Applicant: Mr R Bratt

Proposal: Erection of garage adjacent to approved dwelling and change of use of land to residential

Proposed West Elevation

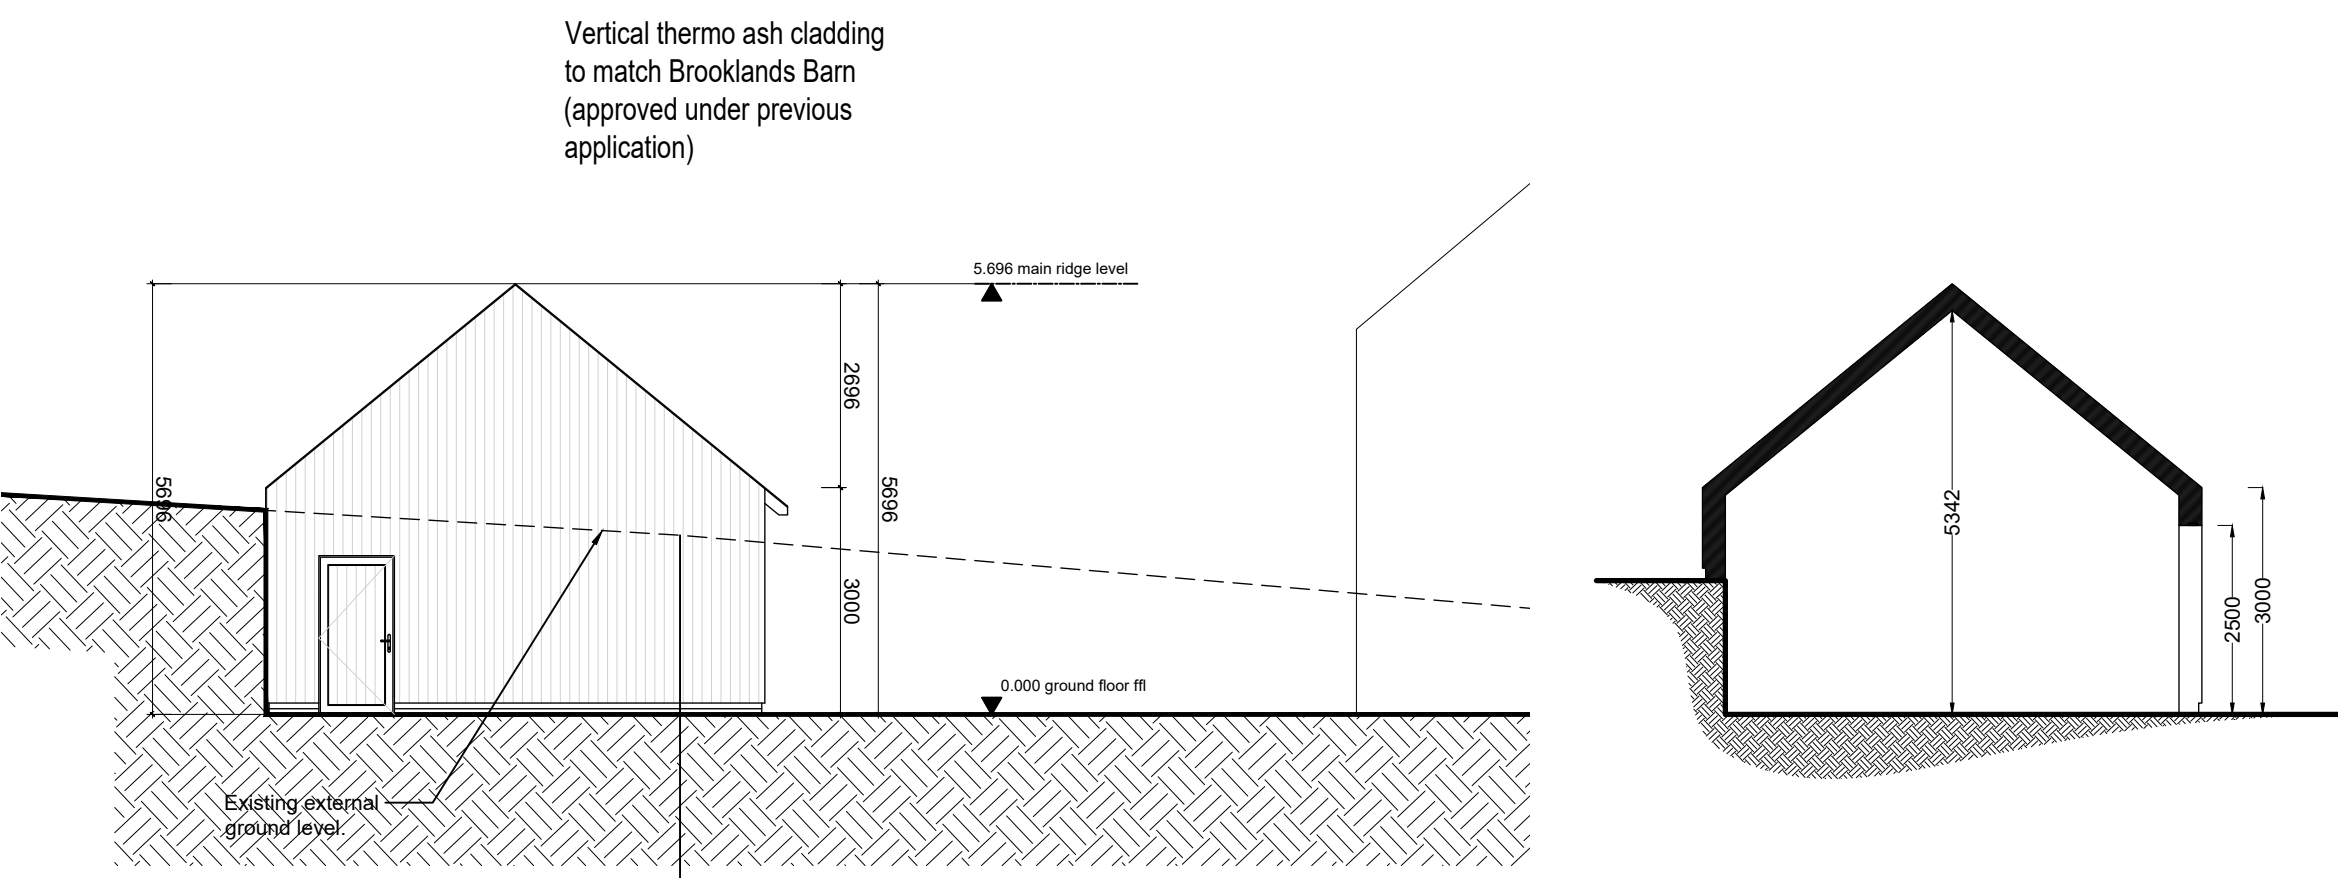
- 8.6. As noted above the proposed garage building is substantially larger than what might be considered a typical domestic garage. The proposed structure would be sited to the north-west of the on-going development at the site and in officer's opinion is poorly related to the main dwelling, appearing somewhat divorced. Whilst materials are proposed to match those proposed on the main dwelling, the overall appearance of the building would appear somewhat more commercial than a residential garage; largely due to the number of bays proposed.

- 8.7. The proposed building, notwithstanding the setting into the landscape, given its siting and scale would be visible within the landscape and would significantly increase the built form at this location. The extent of the proposed hardstanding, again poorly related to the main dwelling, further exacerbates the harm that would be caused by what is a substantial increase in the area of residential use at the site.

1. By virtue of its siting, scale and design the proposed substantial garage building and associated hardstanding, and by virtue of its extent and location the proposed change of use, are not considered sympathetic to the rural context of the site and are considered an inappropriate form of development, that would cause undue and unjustified visual intrusion into the valued rural landscape and open countryside. Further that it has not been demonstrated the proposals would provide a net gain in biodiversity opportunities at the site. The proposals are therefore contrary to the provisions and aims of saved Policy C28 of the CLP 1996, Policies ESD 10, ESD 13 and ESD 15 of the CLP 2031 and Government guidance within the NPPF in respect of conserving and enhancing the natural environment.

DRAWING NUMBER:
4728/20D

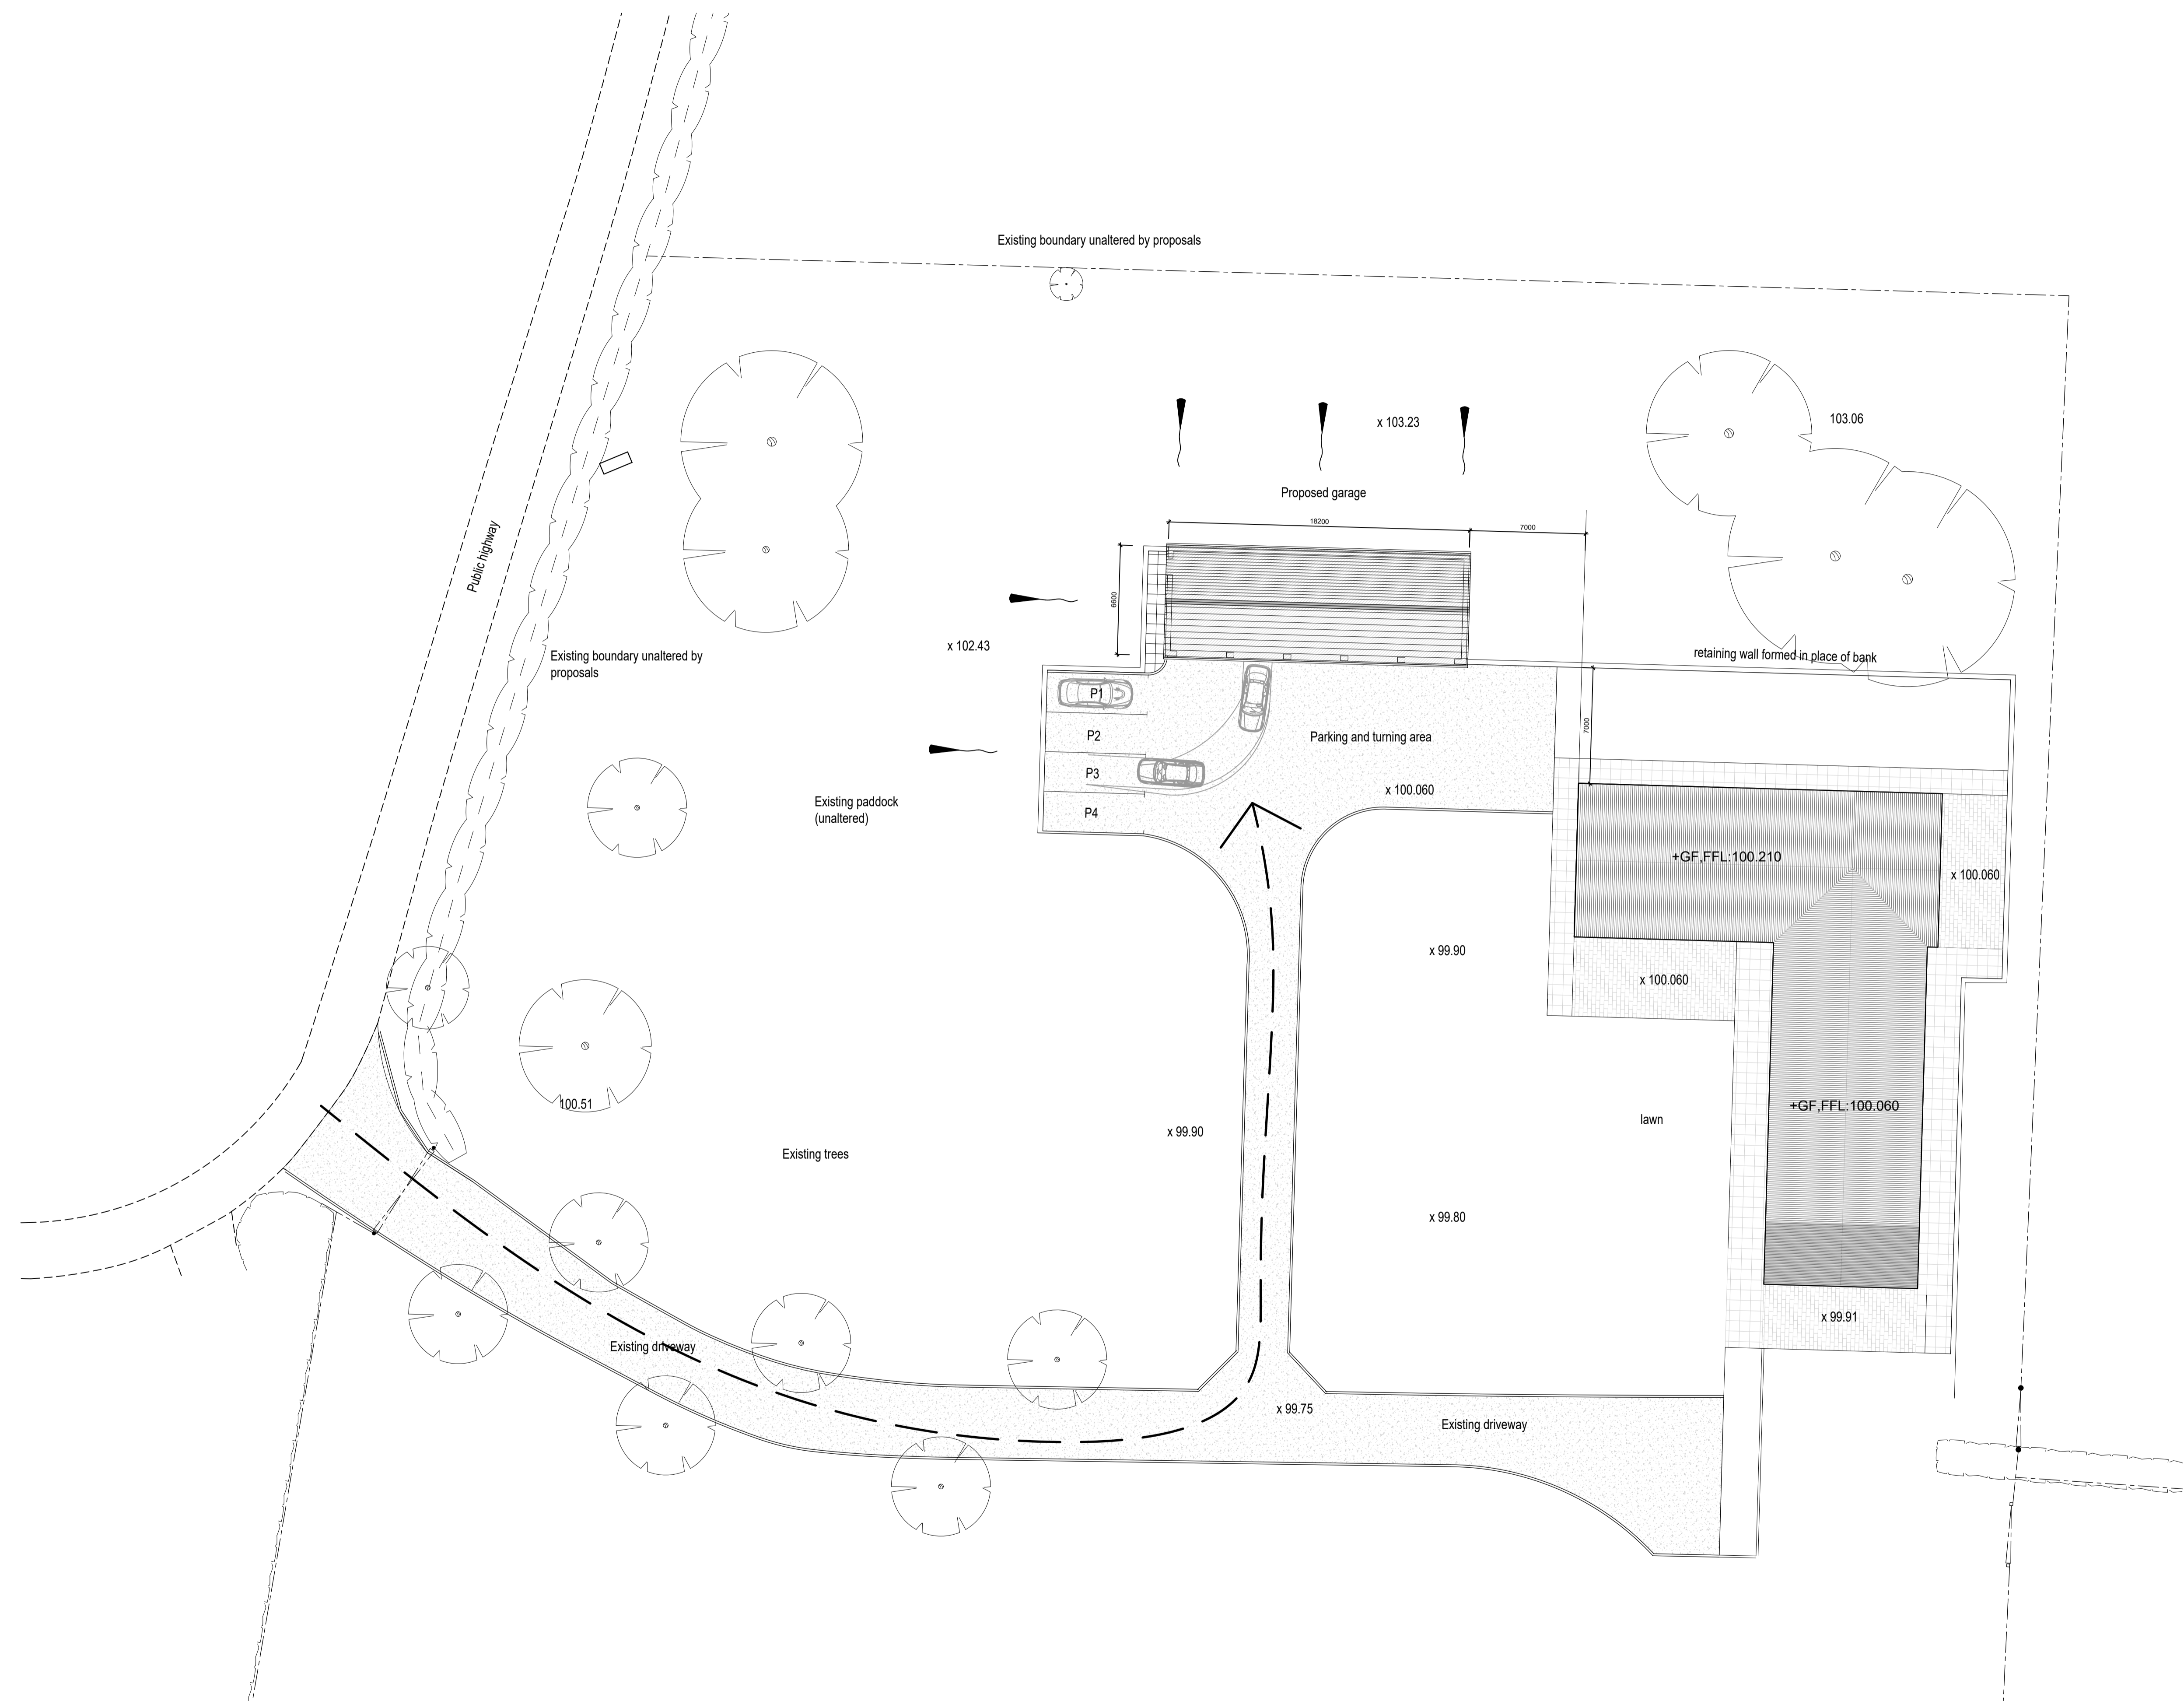
8.3. The current proposals would see the development of a garage and hardstanding wholly beyond the extents of the original residential curtilage on agricultural/paddock land, resulting in a further change of use of agricultural land, extending the area of land in residential use by some 850 sq m (an approximate 73% increase on the original curtilage). The proposed building (a 5-bay garage) would be a substantial building, of a scale above that usually expected for a 5-bedroom residential property. No justification has been put forward for the need for such a large-scale structure, or for the substantial increase in land in residential use, both of which would intrude into the rural landscape.
